Office of
Environment
& Heritage

RE: REVIEW OF ENVIRONMENTAL IMPACT STATEMENT FOR ARTC HEXHAM RELIEF ROADS PROJECT, HEXHAM – SSI - 4992

ATTACHMENT A: OEH REVIEW – OUTSTANDING ISSUES

Key Project Features **Figure 4.1e**

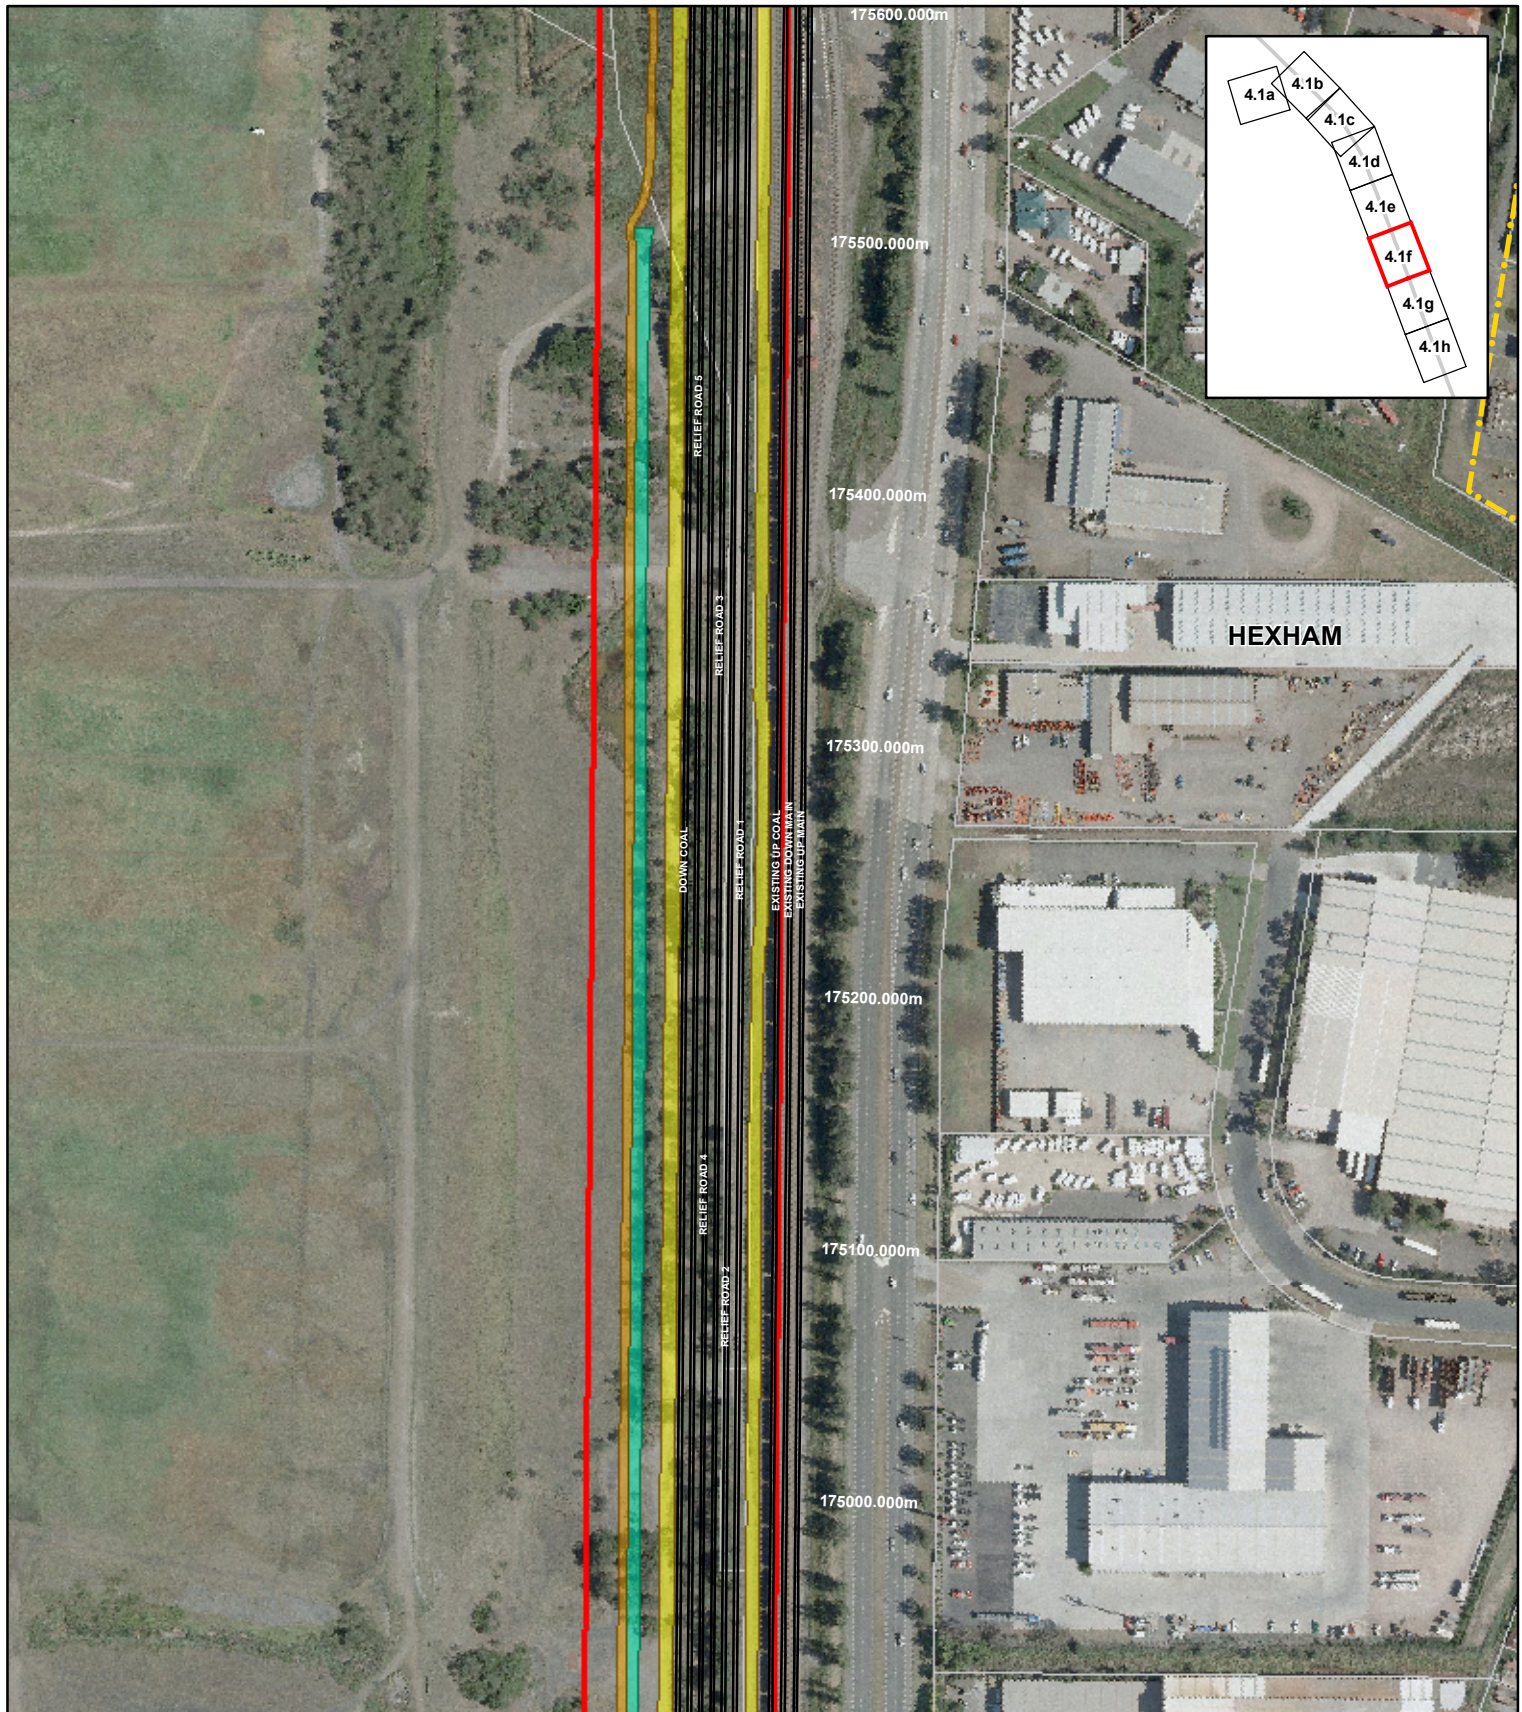
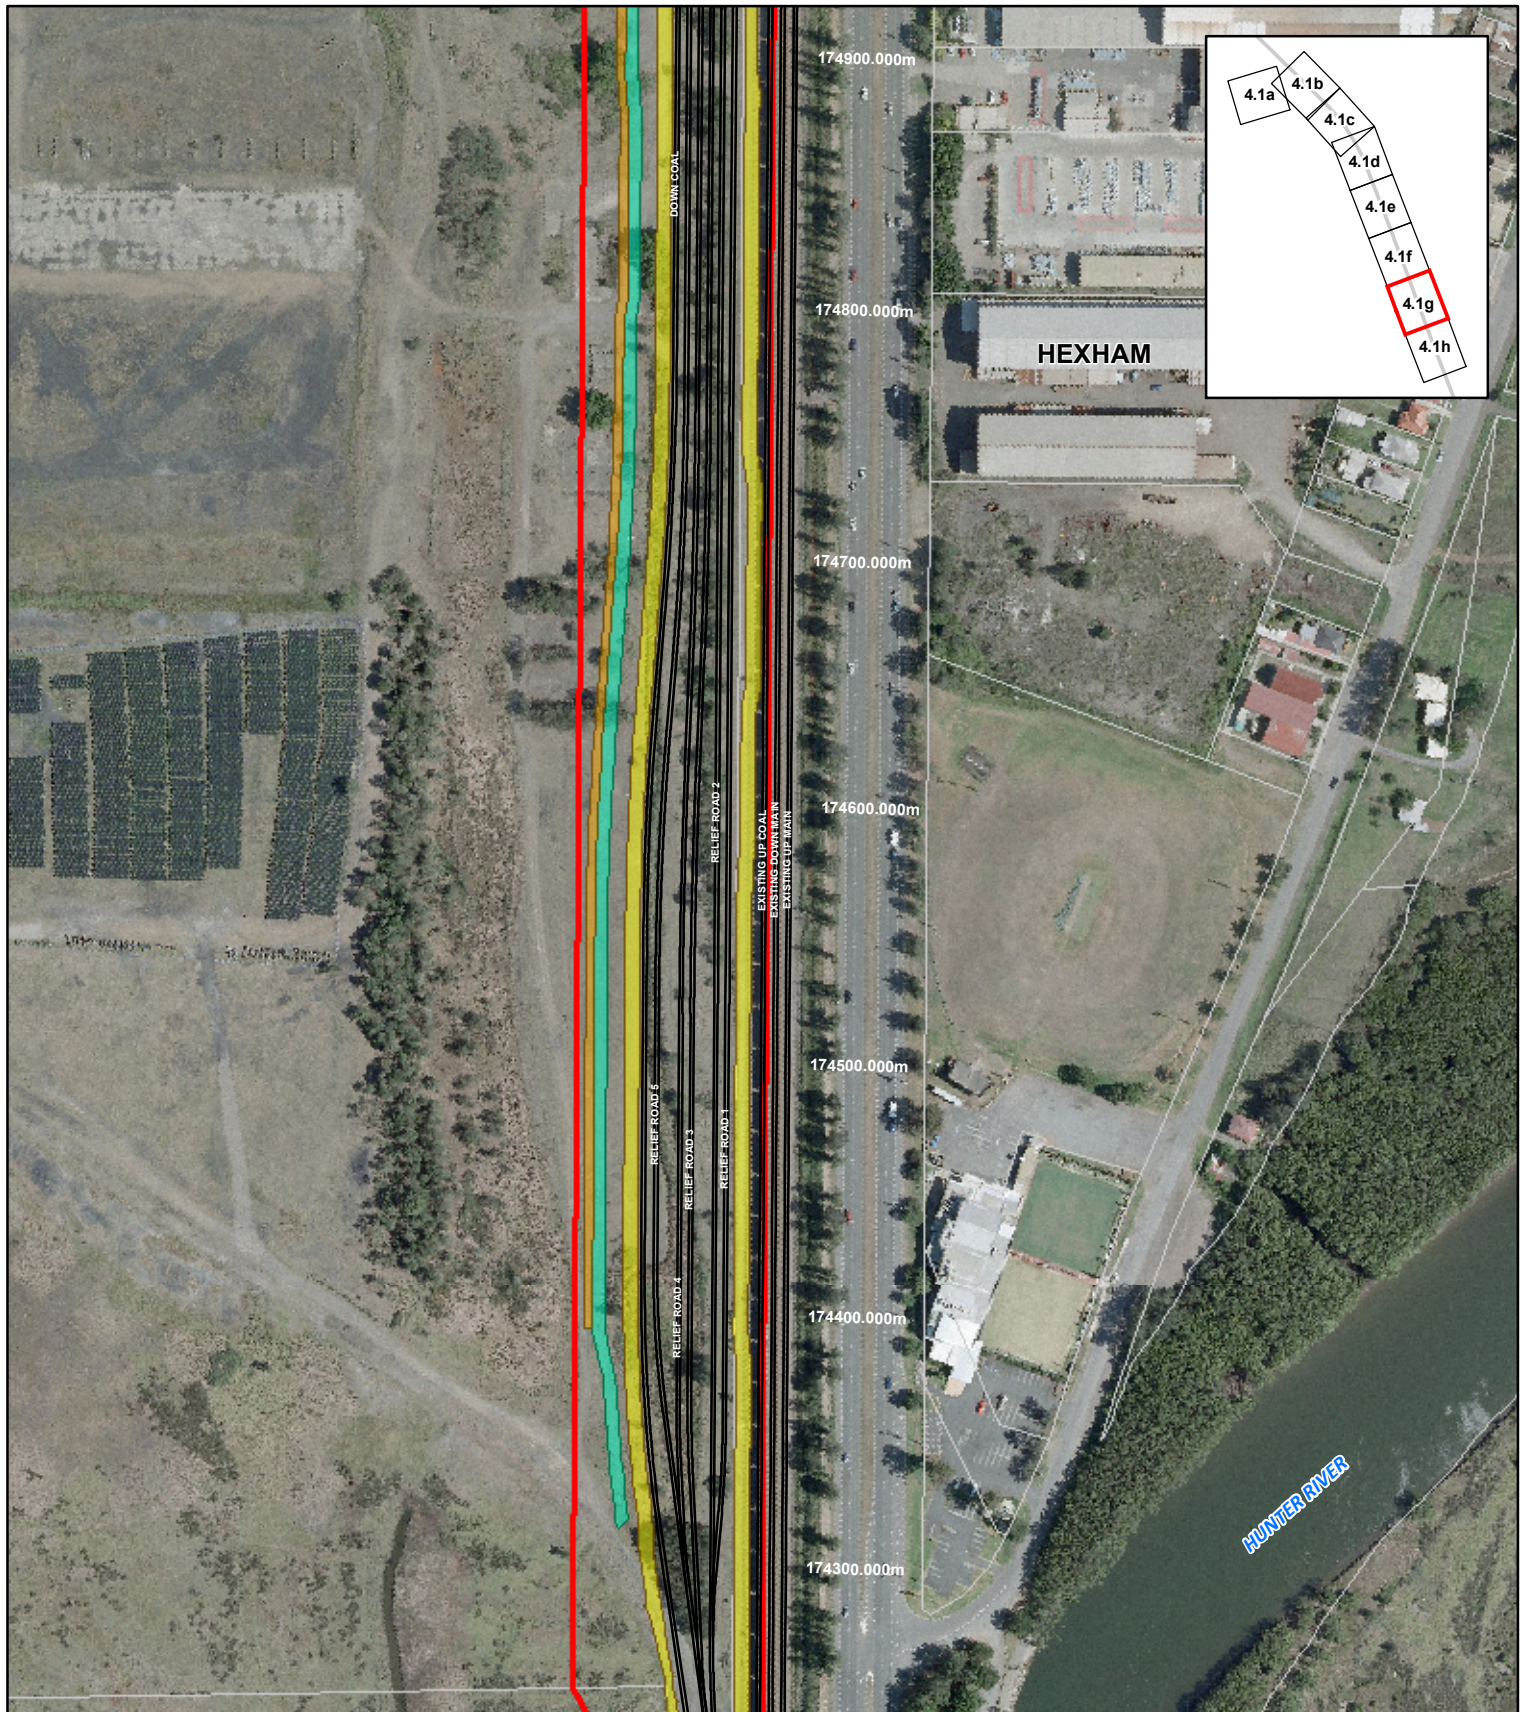
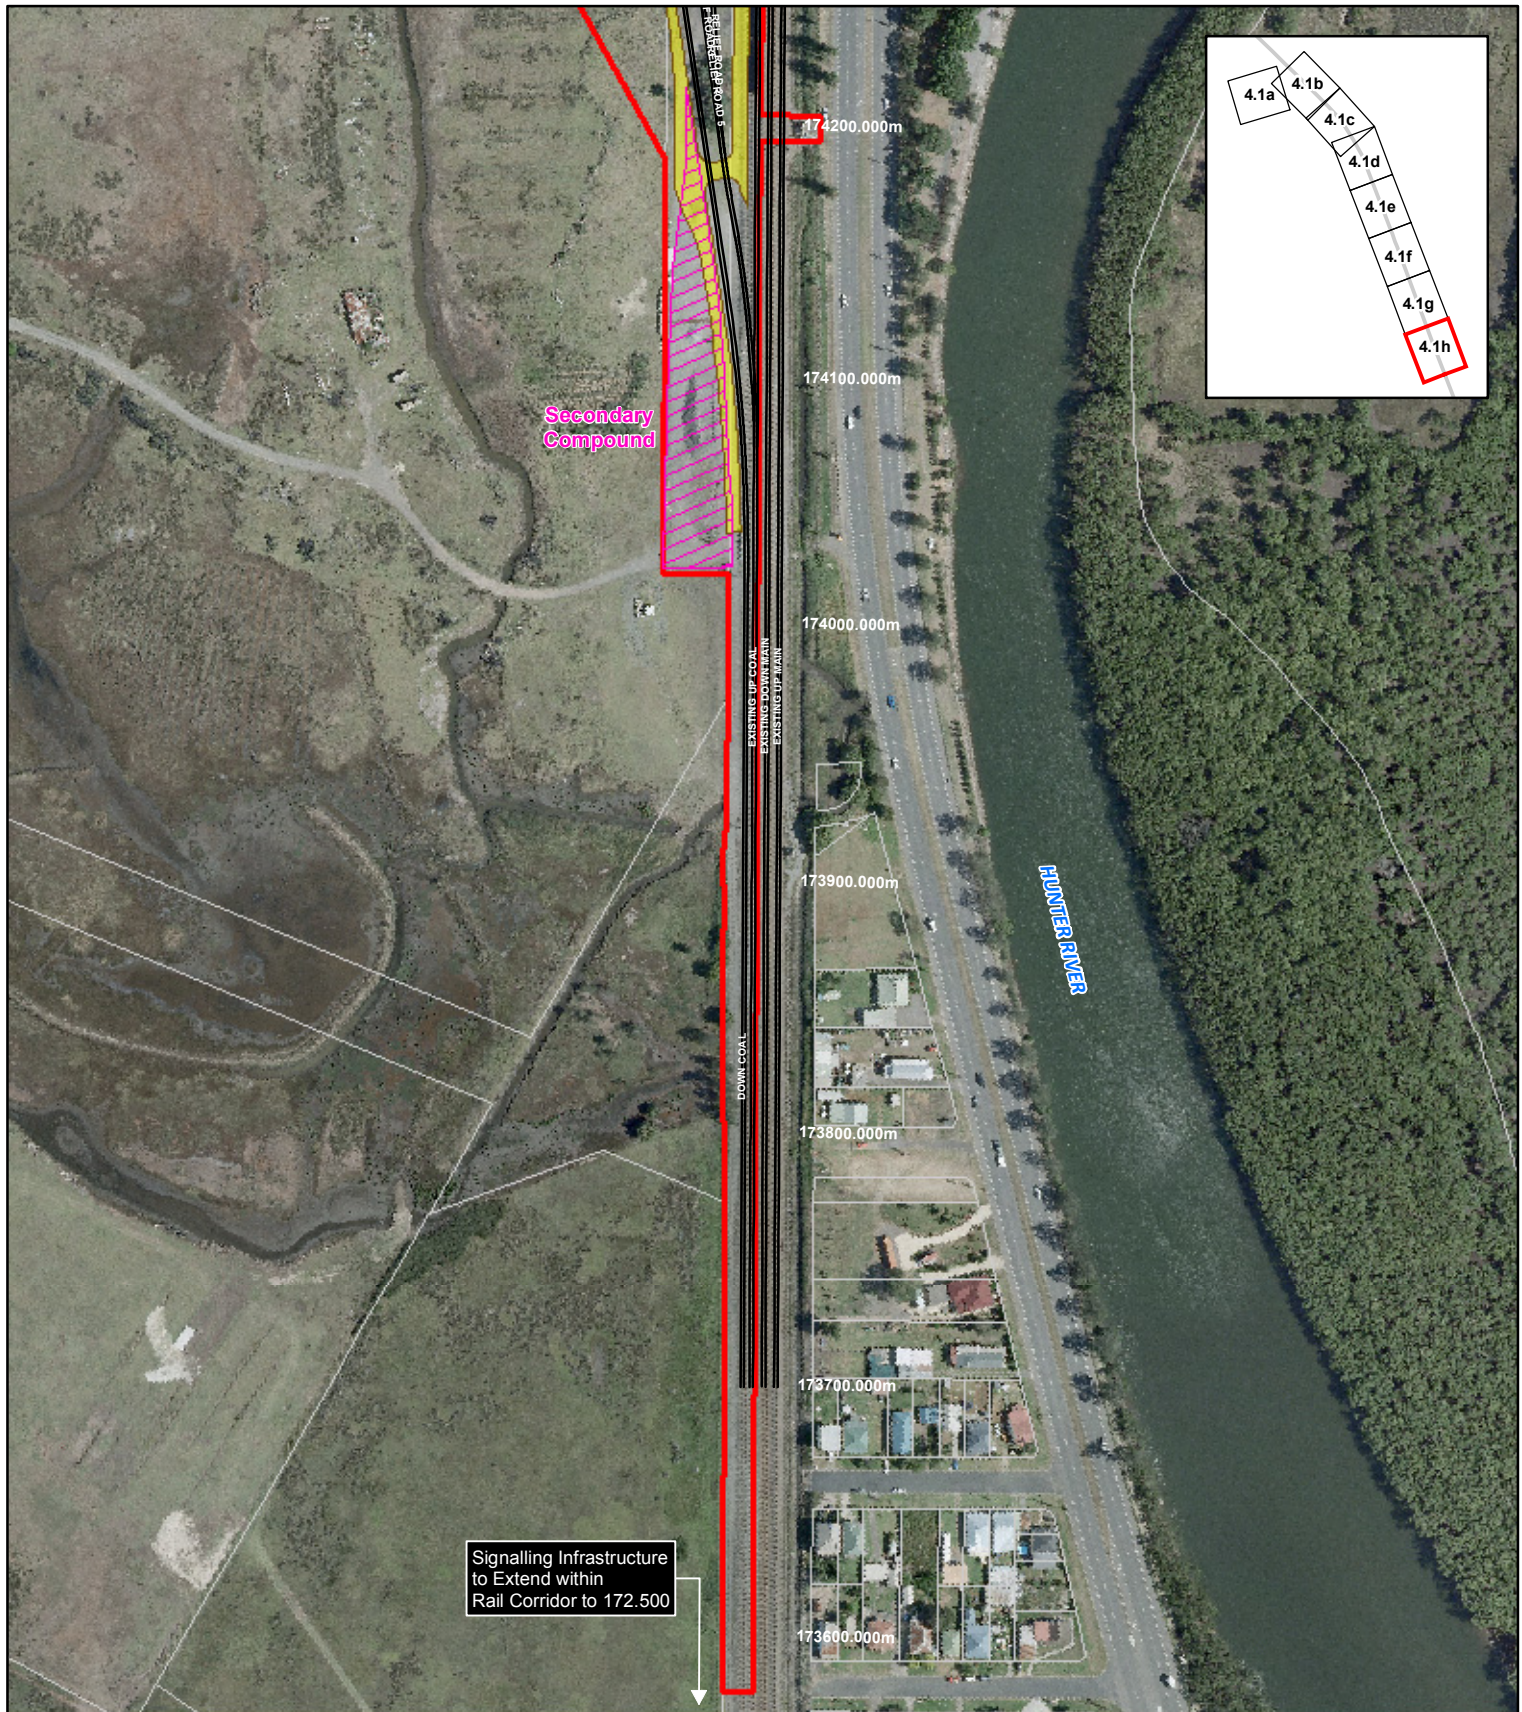
Figures 4.1(e) – (g) show an access track adjacent to the drainage swale, however, it is indicated as “proposed vehicular access” to Lot 312 DP 5874. If this track is to be used for maintenance vehicles such as sucker trucks, then the design of the road must take that in to account. This includes the depth of the excavations required for the road design so that it can cater for heavy vehicles, as well as provision for vehicle turning areas and access points to the swale.

- Recommendation 4.1 – Detail of drainage swale to be provided, including but not limited to inlets, outlets, cross sections (including depth of excavations), capacity, maintenance access and whether it will cater for runoff from the adjacent Train Support Facility.
- Recommendation 4.2 – Detail of vehicle access track to the west of the swale to be provided, including design vehicle loading.

Title: **Impact on Peak 5% AEP Flood Level - Hexham Relief Roads**

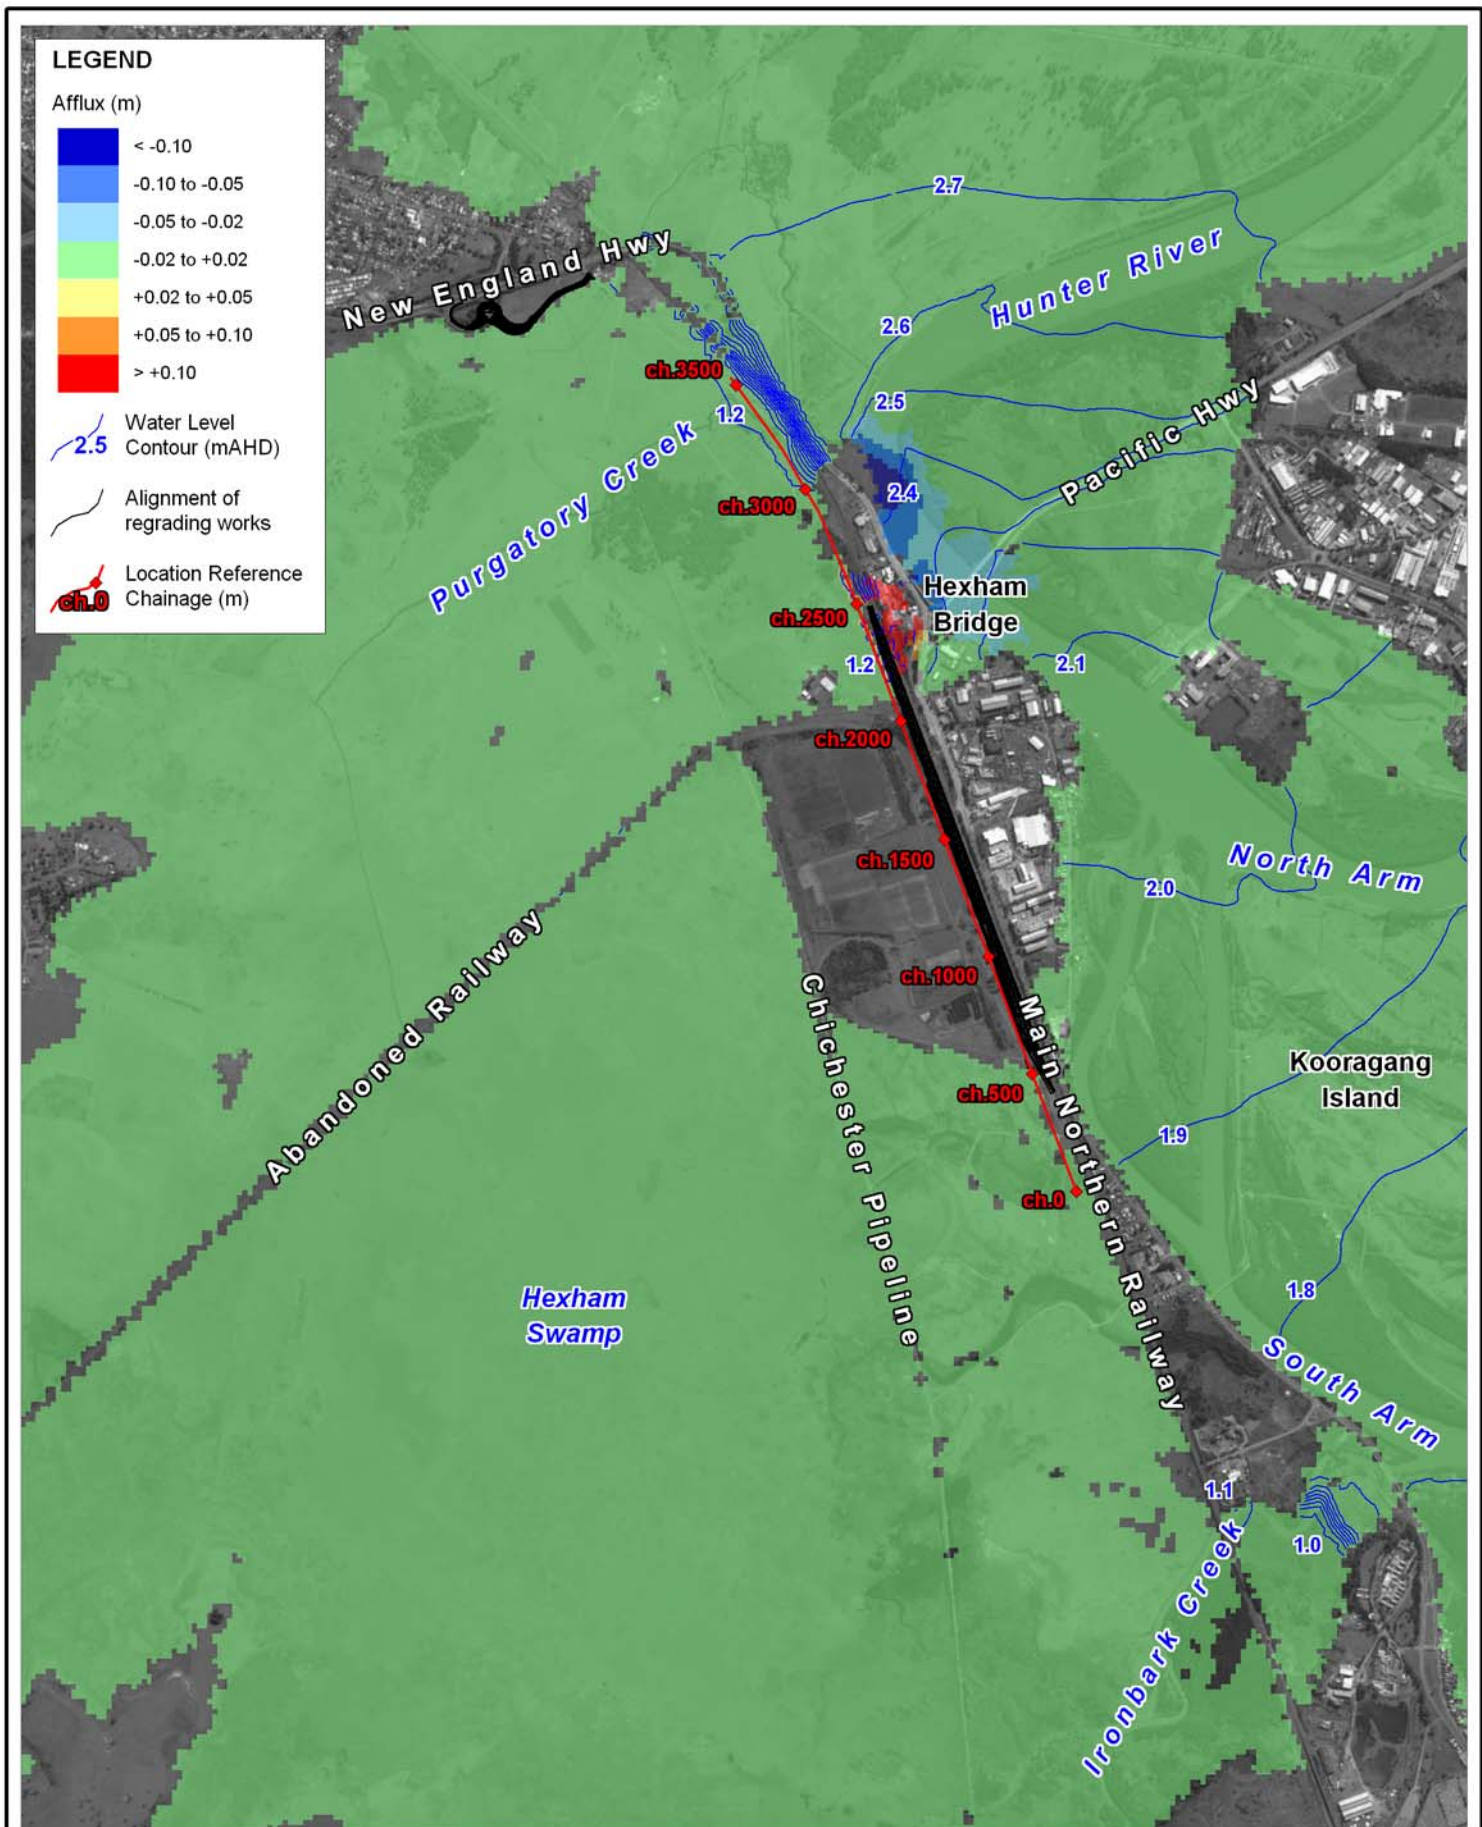
The report states that the impacts in the 2% and 5% AEP design flood events result in increased flood levels to the east of the site, where overland floodwaters become “trapped” behind the new rail embankments. However, no cross drainage structures were included in the assessment, despite the inclusion in the report of the statement “the provision of sufficient cross drainage structures in the affected locations would assist in mitigating the flood level increases”. The location of these flood level increases coincides with the location of existing industrial and residential development.

- Recommendation 3.1 – Update hydraulic assessment to include all proposed drainage structures in model. The assessment also needs to include the updated flooding impacts on adjoining properties.
- Recommendation 3.2 – Prepare a formal project risk management assessment in accordance with AS/NZS ISO 3100:2009 to include the consideration of the full range of flood events up to and including the PMF.
